CITY OF MERCER ISLAND

Pre-Application Meeting (PRE20-045)

Site Location:	4001 WMW		
Lot Size:	31,500sf	Zoning:	R-15 (Single Family)
Brief Project Description:	Subdivide 1 lot into 2 lots.	Documents Provided:	Discussion points, plan set, pre-app form, project narrative, and tree inventory
Applicant Information:			
<small>Name:</small>	Mark Wischman	<small>Email:</small>	mark@wischmanmgt.com
		<small>Phone:</small>	206-909-5559
Second Pre-application Meeting Required:	Not Applicable	NA

4001 WEST MERCER WAY SHORT PLAT
SHORT PLAT MAP

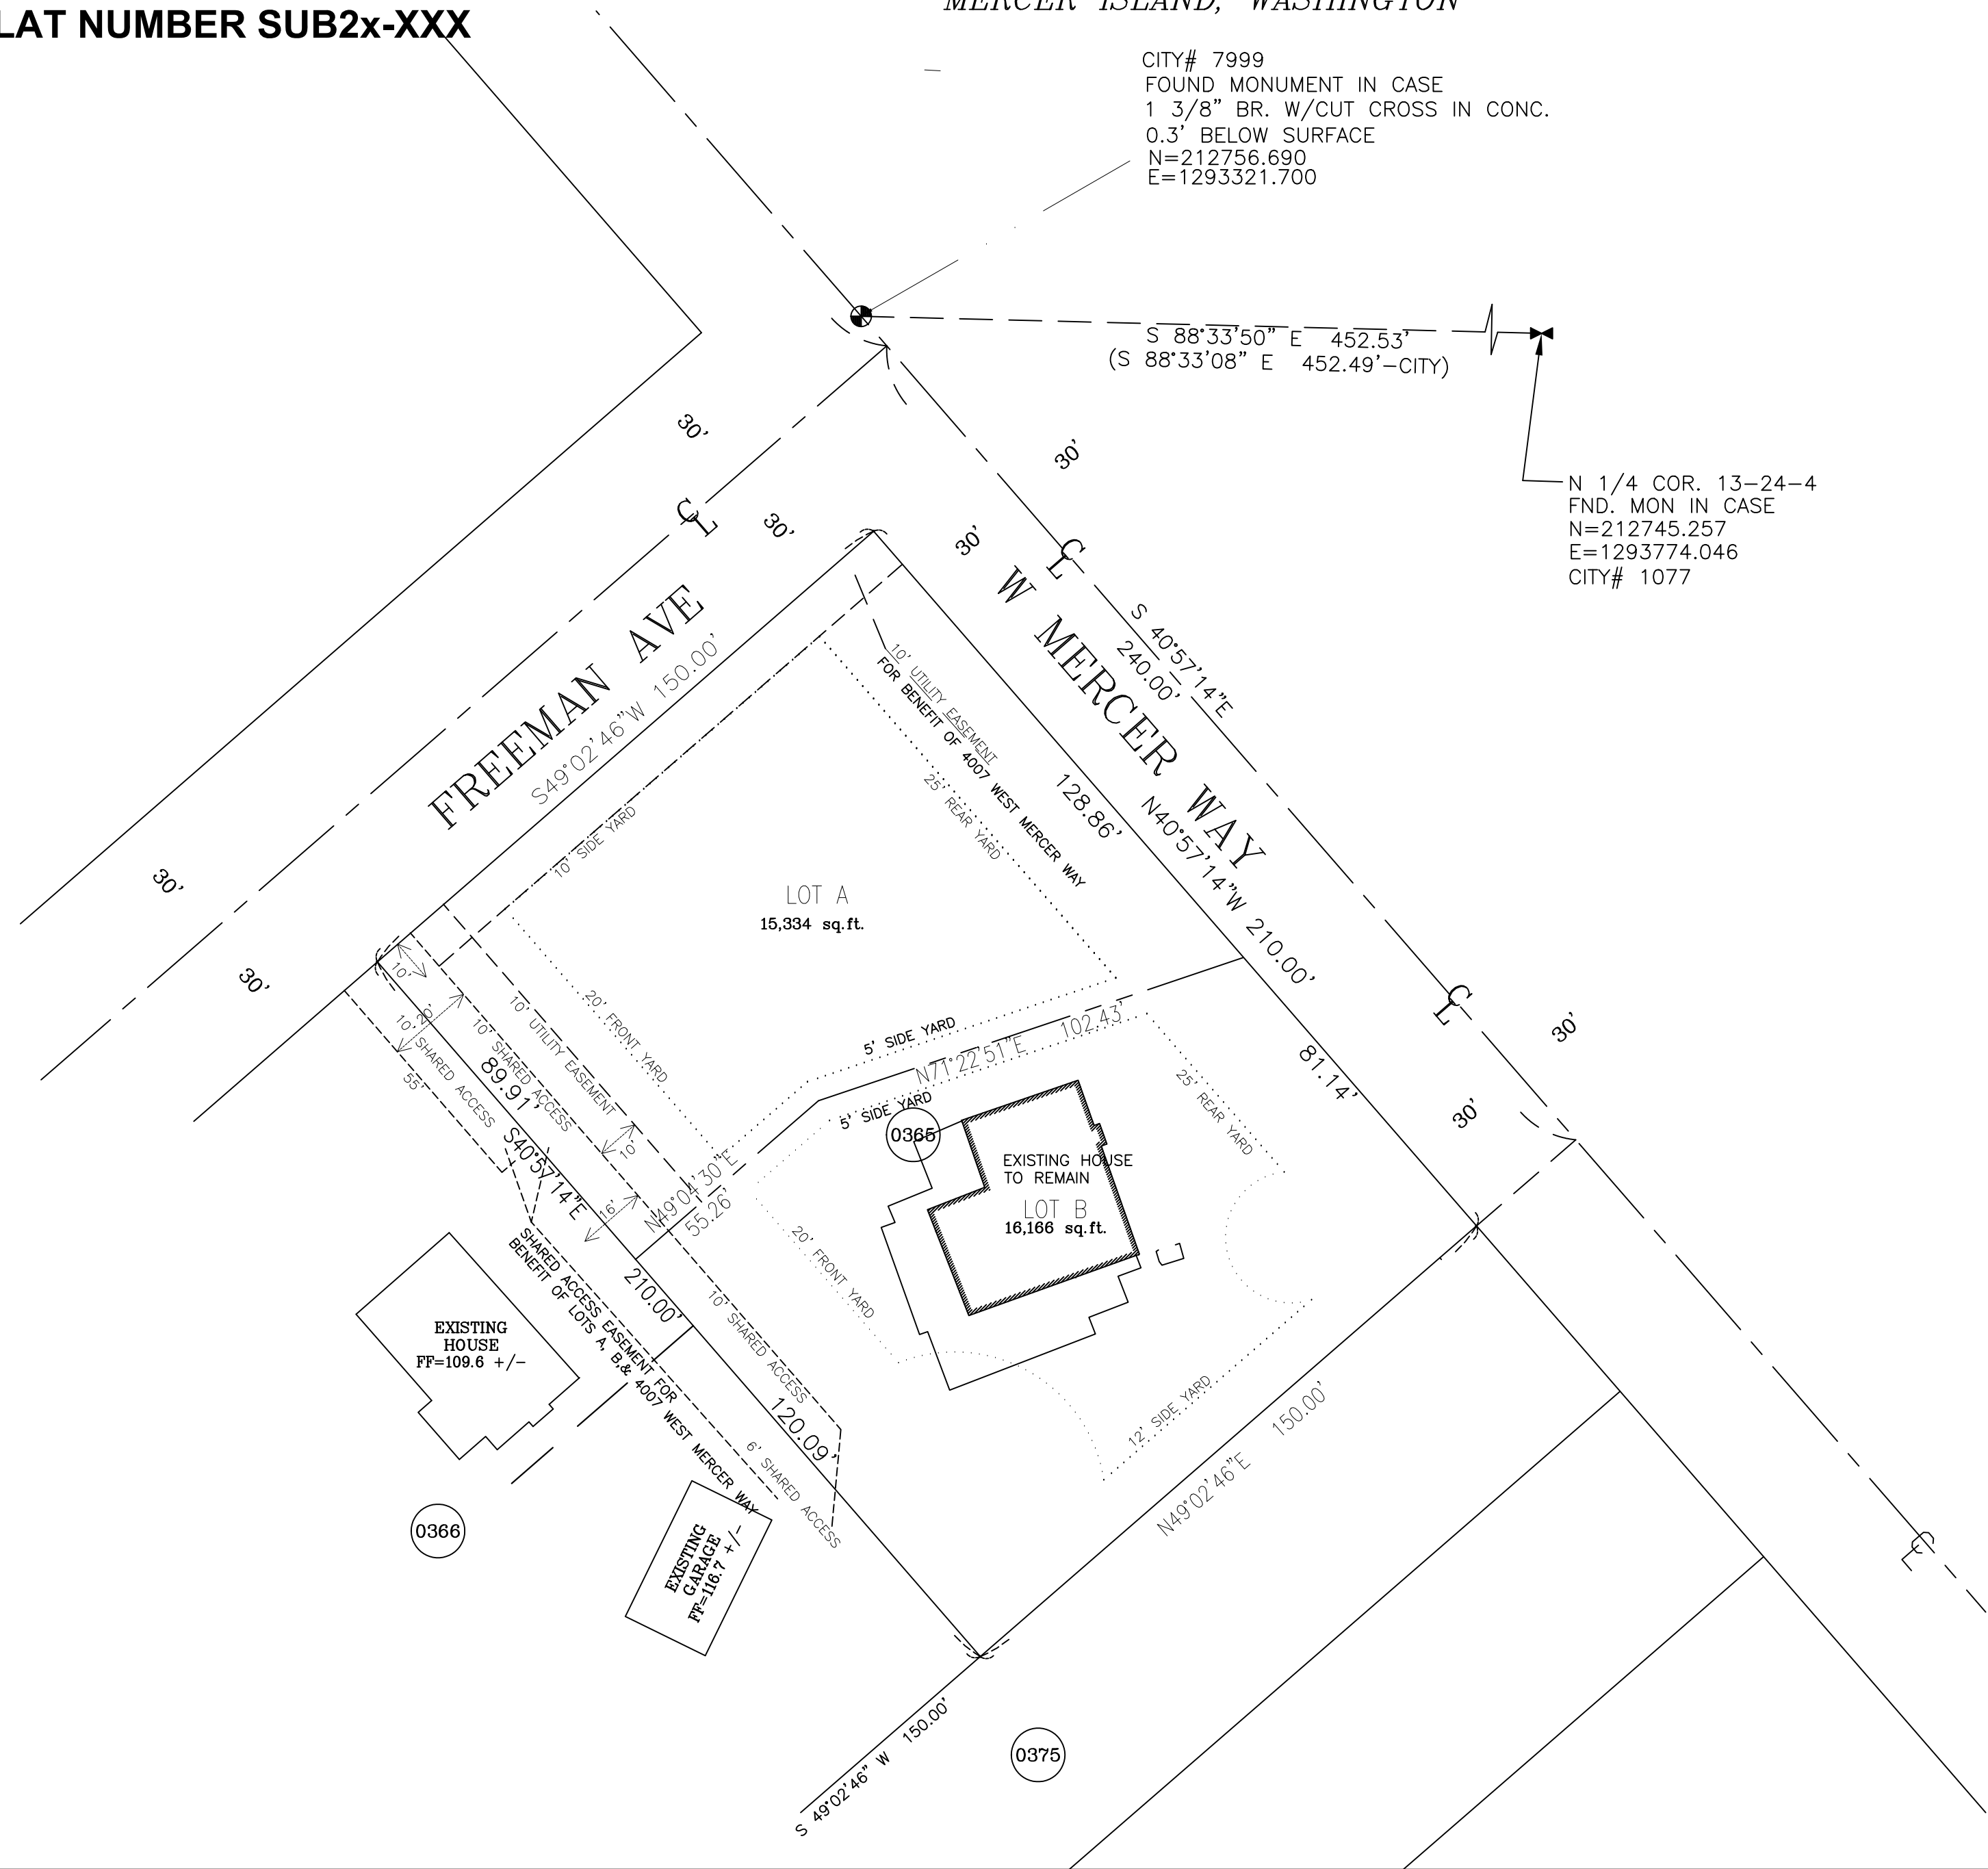
- b. Access both lots of West Mercer Way
 - c. Proposed access road should be 20'. You will need to show why this is not possible. Code Alternatives are considered for extenuating circumstances.

- d. Grade? Can this be reduced?
- e. Fire Hydrant D2-01 is more than 15' from the furthest point of both lots. Lot A= 179' Lot B= 693 +/- . Both would be considered deficiencies. Hydrant D2-01 is capable of 1826gpm at 49psi.
- f. Freeman Ave is only 11' wide. Current access to the "cabin" is the same.
- g. Proposed access from WMW to Lot B is 345'. This would require 20' roadway.
- h. As presented Lot B would have deficiencies with:
 - i. Distance from hydrant.
 - ii. Distance from fire access road to furthest point of structure
 - iii. Grade
 - iv. Width of roadway
- i. As proposed Lot A would have deficiencies with:
 - i. Distance to furthest point of structure (depending on placement)
